Gatwick Northern Runway Project

West Sussex County Council response to Issues Trackers prepared by GAL

September 2023

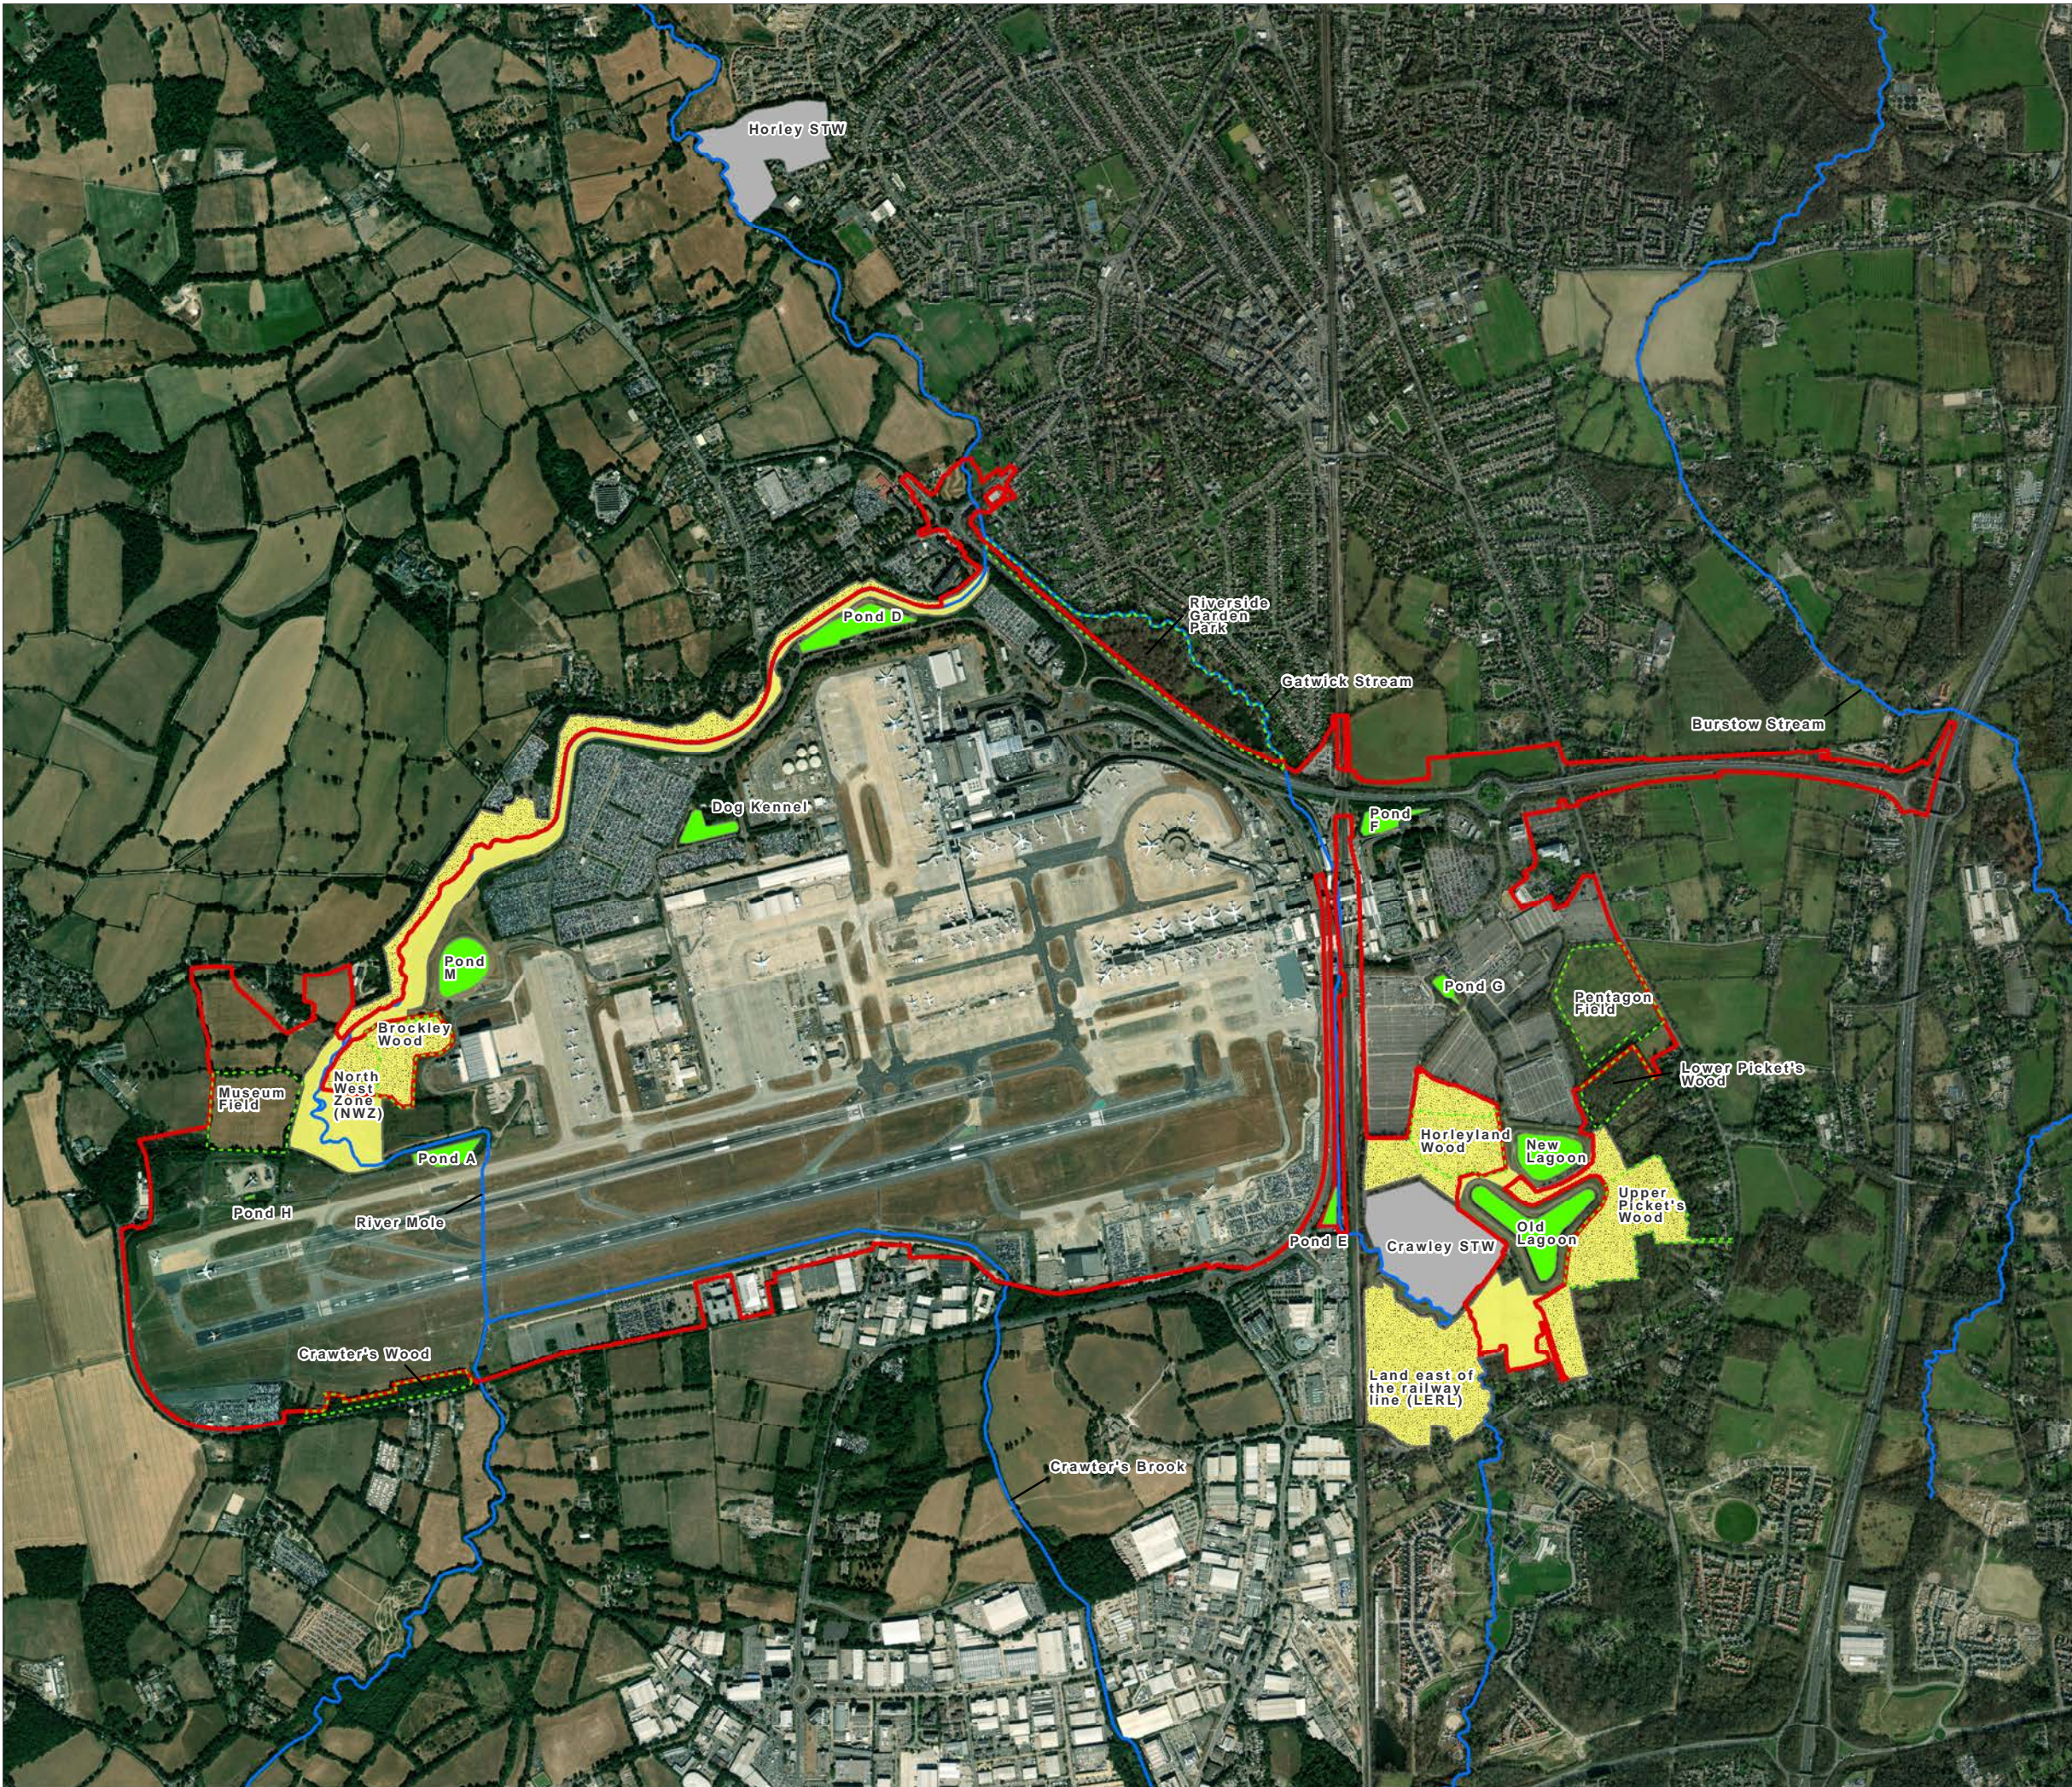
WSCC Issue	When issue was raised
Ecology and Nature Conservation	
Baseline Survey - PEIR Fig. 4.2.1c is labelled 'Existing Location/Environmental Features identified in PEIR'. However, it does not show all the environmental features identified in the PEIR and is therefore misleading. The Phase One Habitat Survey (Fig. 9.6.3), for example, shows additional environmental features such as woodlands, hedgerows and neutral grasslands, which should also feature in Fig. 4.2.1c.	Autumn 2021
Baseline Survey - Linear features, such as streams, ditches and hedgerows, didn't show up very clearly in the Phase One Habitat Survey (Fig. 9.6.3) presented in the PEIR. It is requested that they are highlighted. e.g. Crawler's Brook is highlighted in Fig. 4.2.1c but not shown in the Phase One Habitat Survey.	Land and Water TWG 10 th May 2022
Survey Extent -Requested that the Phase 1 Habitat Survey is extended beyond the Project Area.	Autumn 2021 Land and Water TWG 10 th May 2022
